Our Case Number: ACP-324410-26

Re: Proposed West Clare Railway Greenway Section 1: Kilrush to Kilkee Project
Kilrush to Kilkee via Moyasta, Co. Clare

Ref: ACP 324410-26 - West Clare Greenway – Kilrush to Kilkee

- Proposed Development
- Sensitive Bird Areas
- Habitat Screening**
- Existing screening
- No Existing Screening
- Needs Vegetation
- Vegetation lost

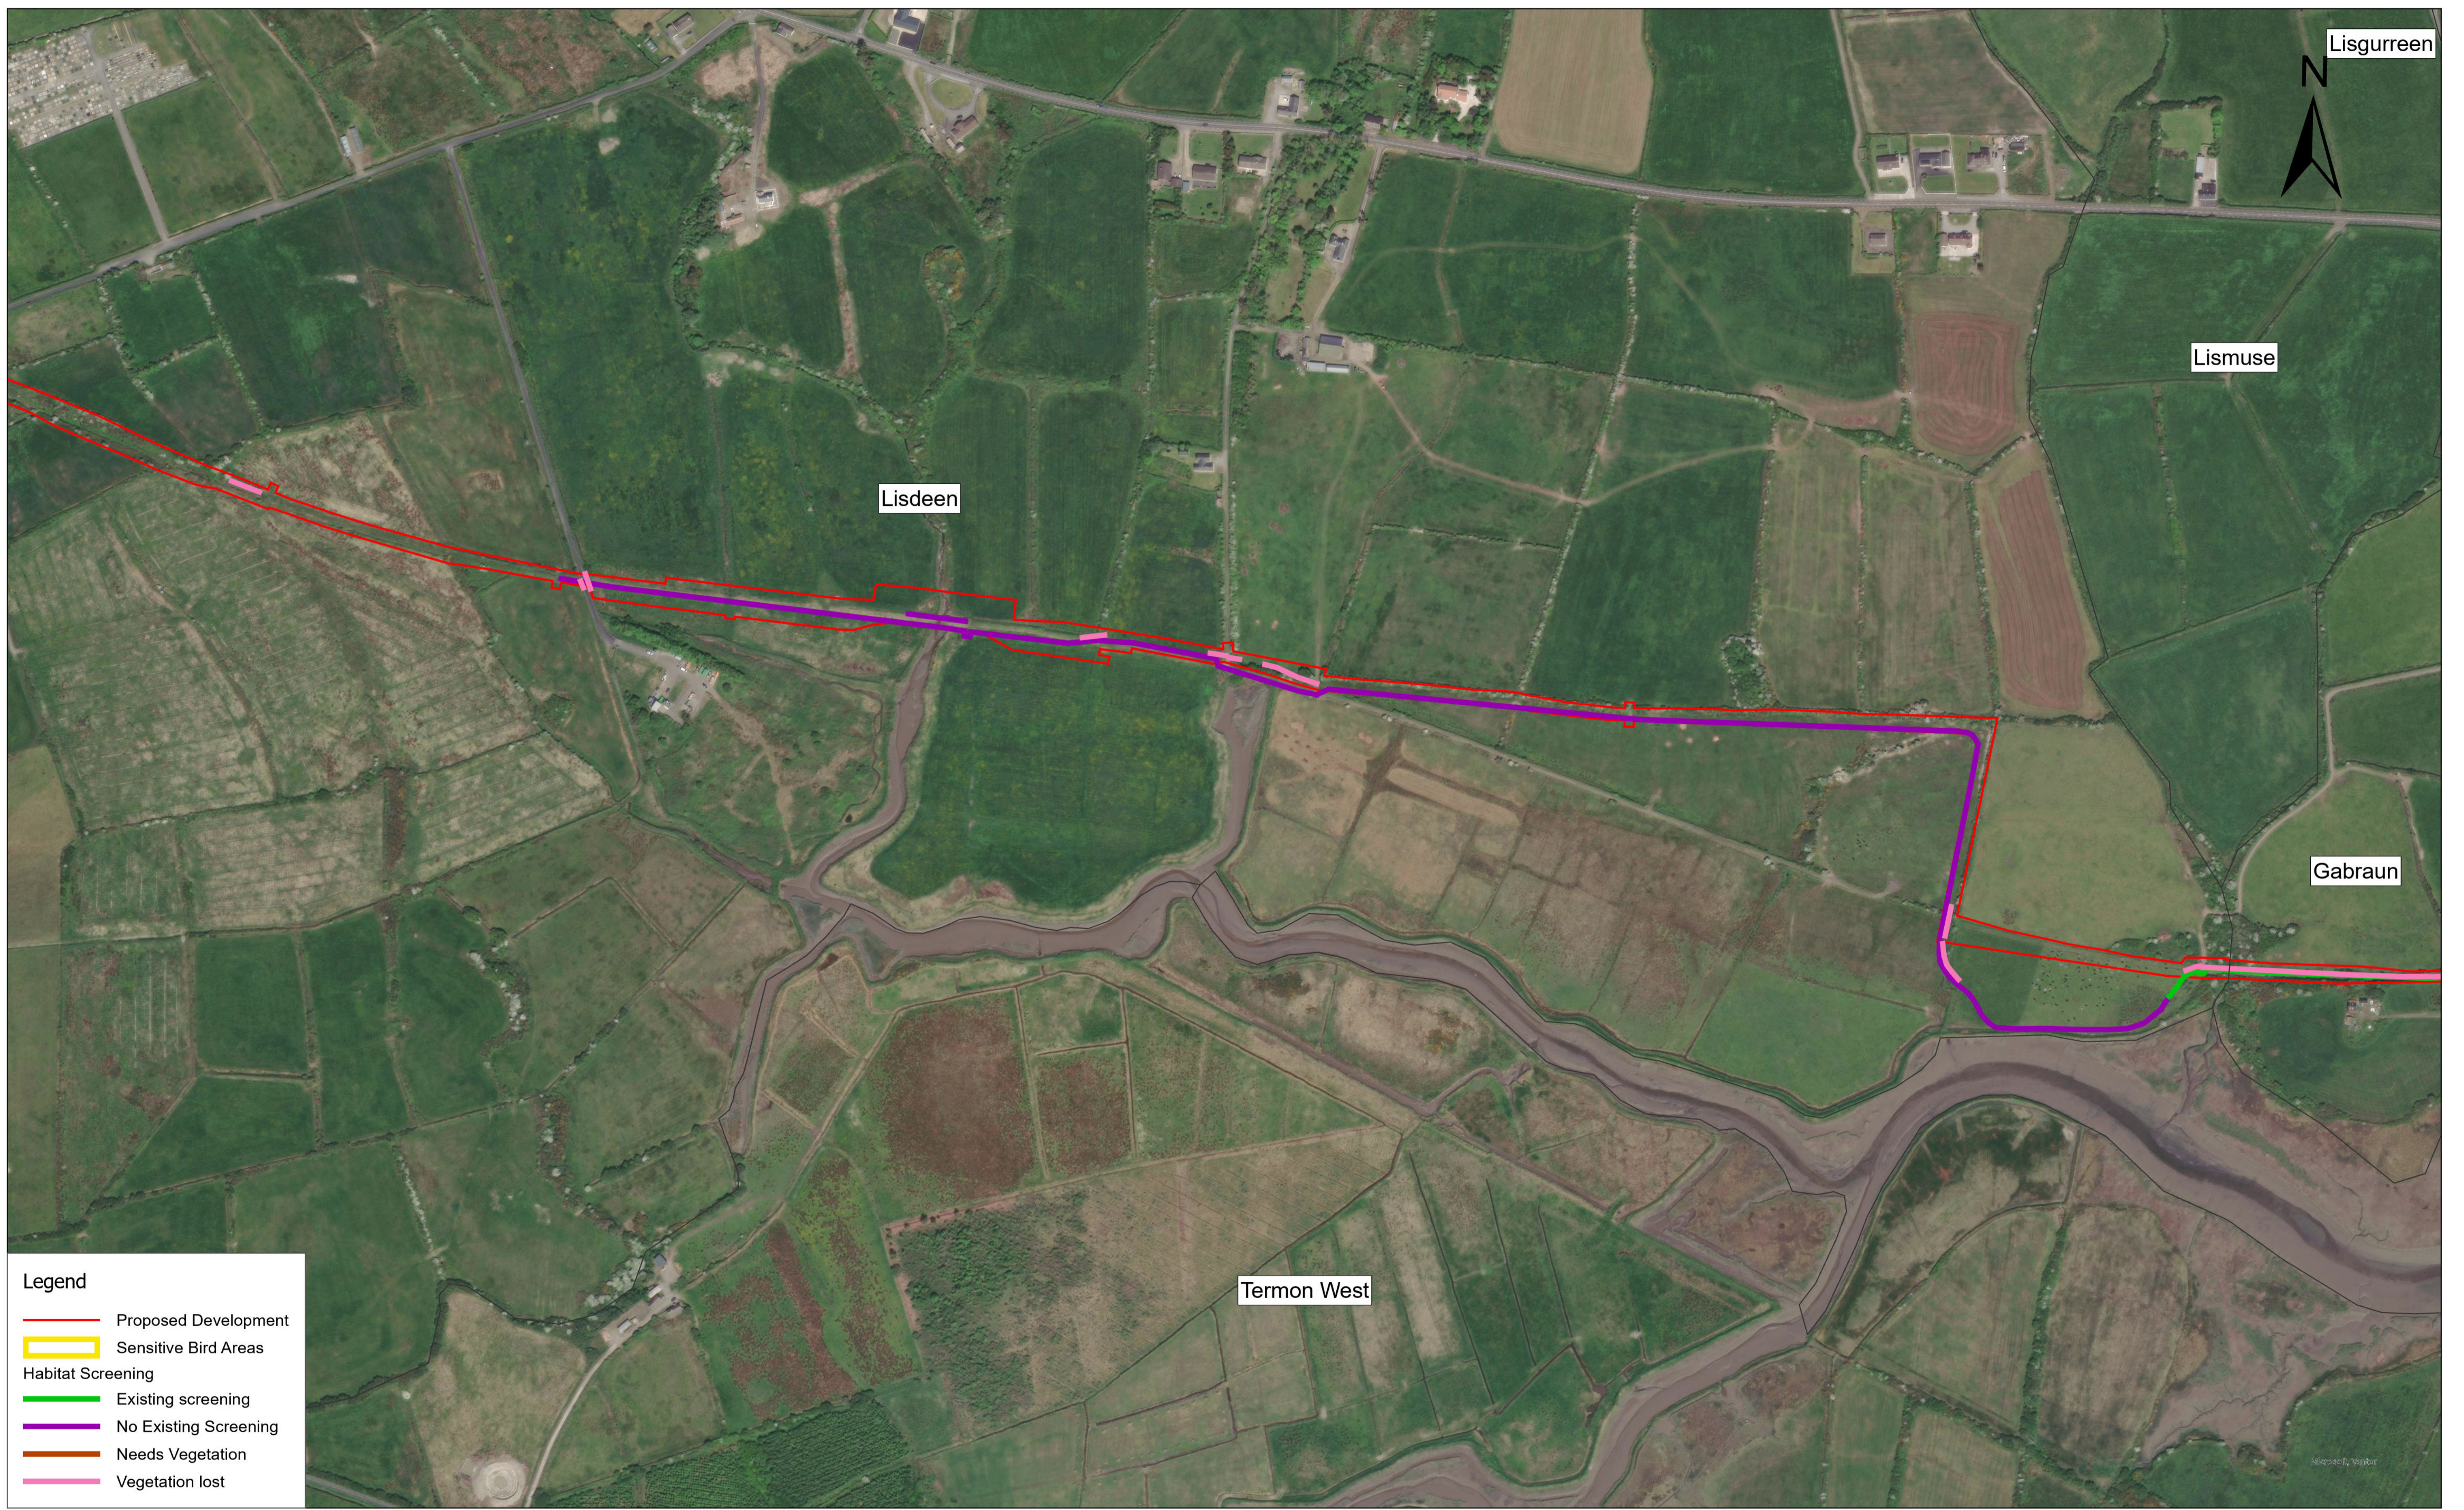
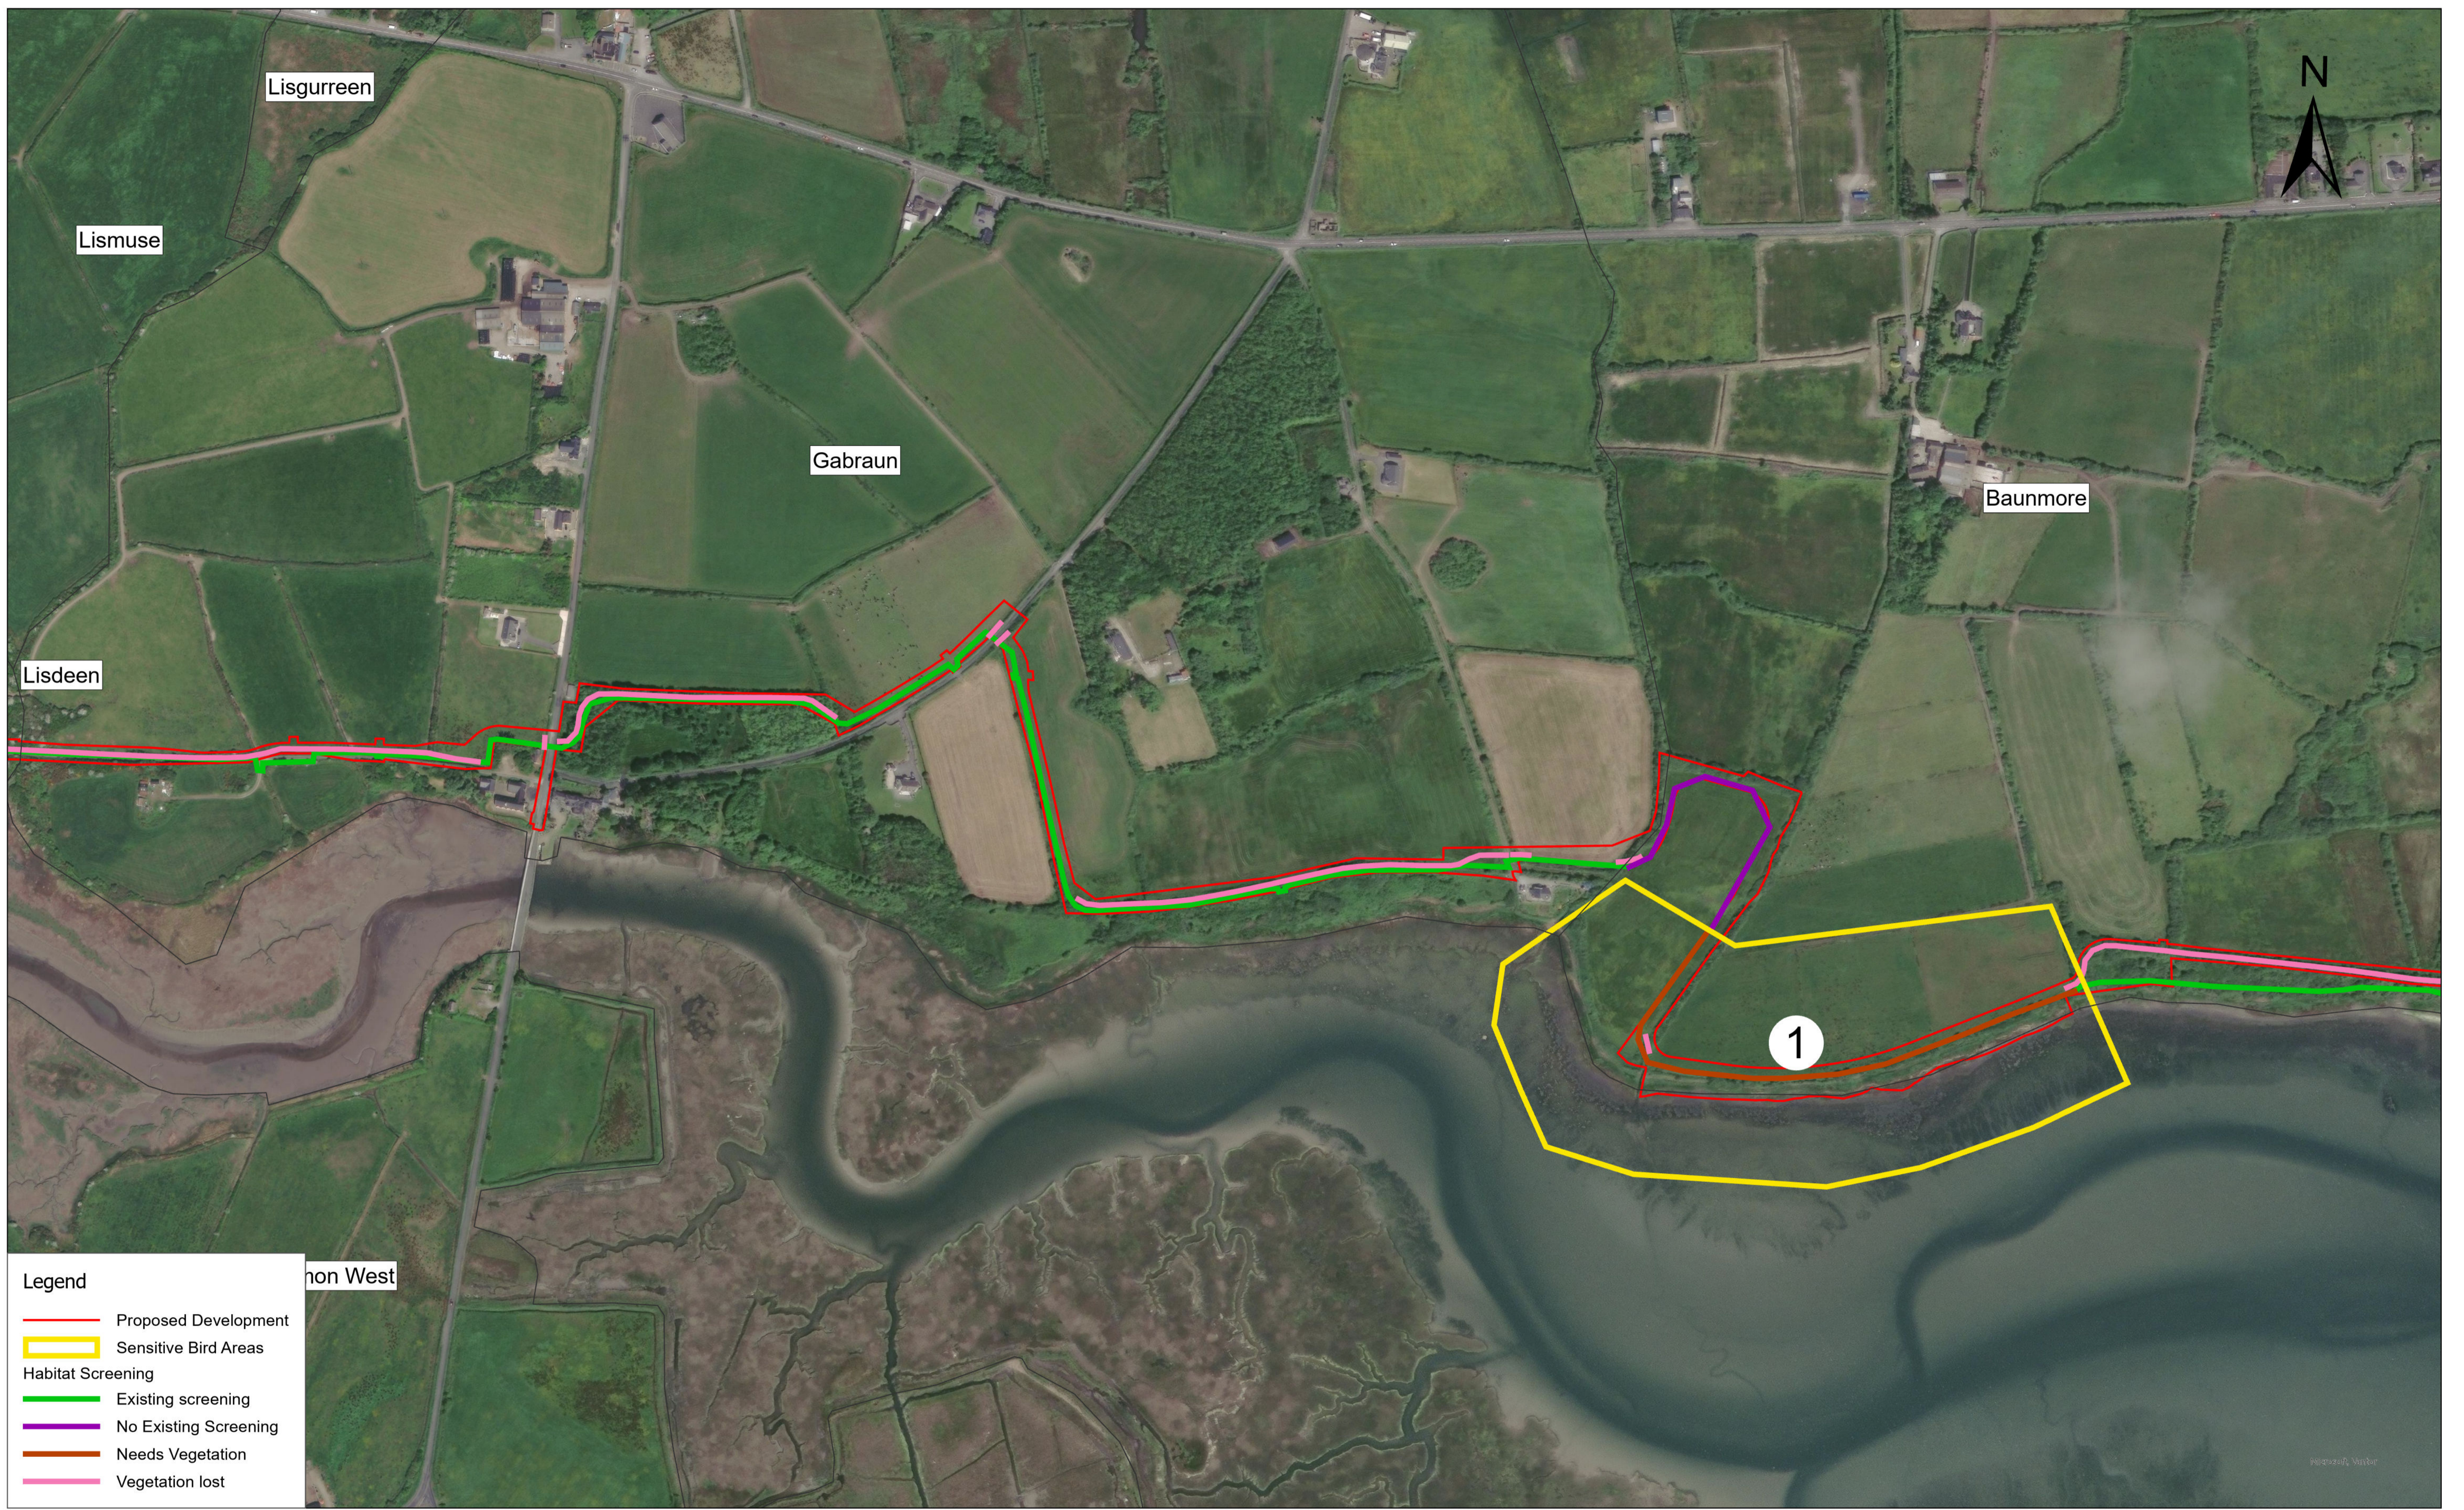
Sensitive Bird Areas (SBAs) are presented by the consultants following their survey work undertaken along with mitigation measures and conclusions. These SBAs are presented in a map extracted from the SBA Appendix, see figure 3 below. They are defined on page 29 of the Natura Impact Statement as “areas around Poulasherry Bay where the proposed development

is close to the coast and where there is no existing screening or, incomplete screening, and therefore could be impacted by the proposed development. Important areas for birds which are not close to the greenway are excluded.” Sensitivity is not defined by the number and distribution of the bird species within Poulmasherry bay itself but rather the level of exposure of the birds to disturbance. This needs to be considered more fully.

The presentations for each SBA includes the numbers of birds of different species recorded present at different distances out to 500m. BirdWatch Ireland staff reviewed the data provided and outline our response to below. In 8 of the 9 SBAs the majority of the individual birds recorded are of species that are of high or moderate sensitivity. In addition, for every SBA it is repeated that a “small” number of birds were found when this number actually varies from 12 to 585 birds. There’s no definition of small provided. Within 100m of the greenway the following is summarized from the data:

It is unquestionable that Poulasherry Bay and several key areas along the route of the proposed greenway are of very high importance for wintering waterbirds. It is not credible that it can be concluded that the addition of hedgerow planting as a screen could mitigate the visual and audible disturbance from people and dogs. Poulasherry Bay is noted as being a site where the birds are predominantly undisturbed and unhabituated to disturbance.

The mitigation for disturbance proposed is screening with planted materials in Sensitive Bird Areas and a 1.4m fence over Moyasta bridge. It is repeated through the Sensitive Bird Area document that there will be no change to the bird numbers in the area as a result of the screening. The NIS anticipates that adequate fast-growing plants and trees will be at stage of robustness to screen people and dogs and the noises they make to prevent disturbance within the 24-month period to build the greenway. It is difficult to imagine that this screening would prevent disturbance not to mind how many plants will fail to establish and the time it will take.
